CITY OF PORTLAND, MAINE
PLANNING BOARD

December 18, 2013

Project Name: Studios at 46 Market Street
Address: 46 Market Street
Applicant: Market Milk Partners, LLC

Studios at 46 Market Street
46 Market Street
Level III Site Plan and Subdivision Review
2013-245
Market Milk Partners, LLC, Applicant

Drawing file: 1_28_14 revisions / Sidewalk & Warning Pad details.pdf

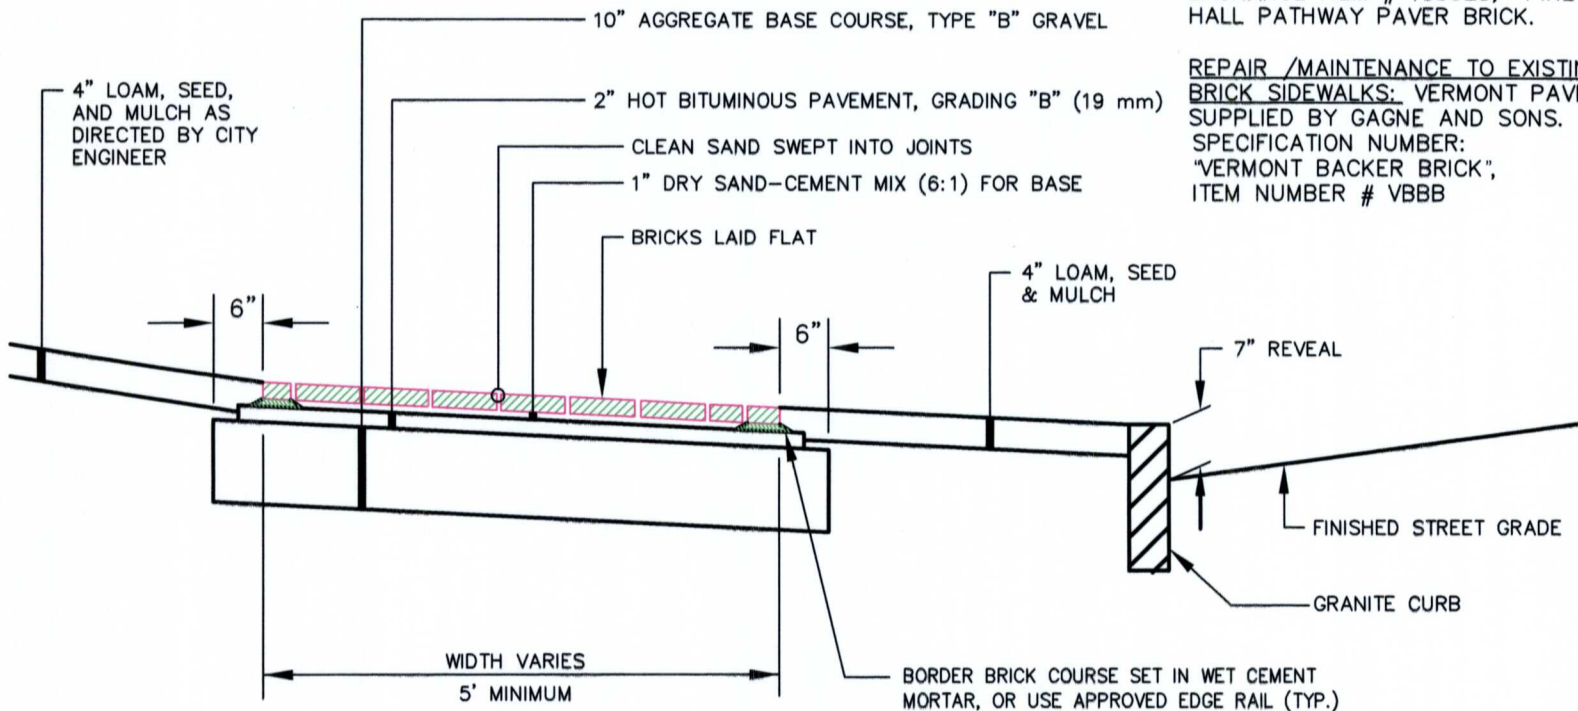
2. The applicant shall provide plans, stamped by a licensed engineer and including details, depicting:
 - a. the reconstruction of the ramp at Milk and Market Streets to include a standard detectable warning panel and flush granite curb, and

- b. the reconstruction of areas of sidewalk on Market Street to eliminate tripping hazards for review and approval by the city's Department of Public Services and Planning Authority;

1. The applicant is requested to re-build the sidewalk ramp at the corner of Milk and Market Streets installing a detectable warning panel for the historic district per Figure I-7A on page 40 of the City's Technical Manual. The applicant is also request to install a short section of flush granite curb in conjunction with this ramp. The City may have a piece of granite curbing stored on outer Congress St which may be used at no cost to the applicant except to pick up and transport. The applicant is requested to use the Pinehall Pathway Pavers bricks when rebuilding this ramp.

2. There are two potential tripping areas in the Market St. sidewalk adjacent to sidewalk ramp. One next to the building corner and the other around the catchbasin headstone. The applicant is requested to remove the brick as necessary in these two areas and reconstruct as necessary to eliminate these tripping hazards. Again, the City may have bricks at the outer Congress Street storage area which will match the existing brick. The applicant is welcome to use these brick as necessary to facilitate these repairs.
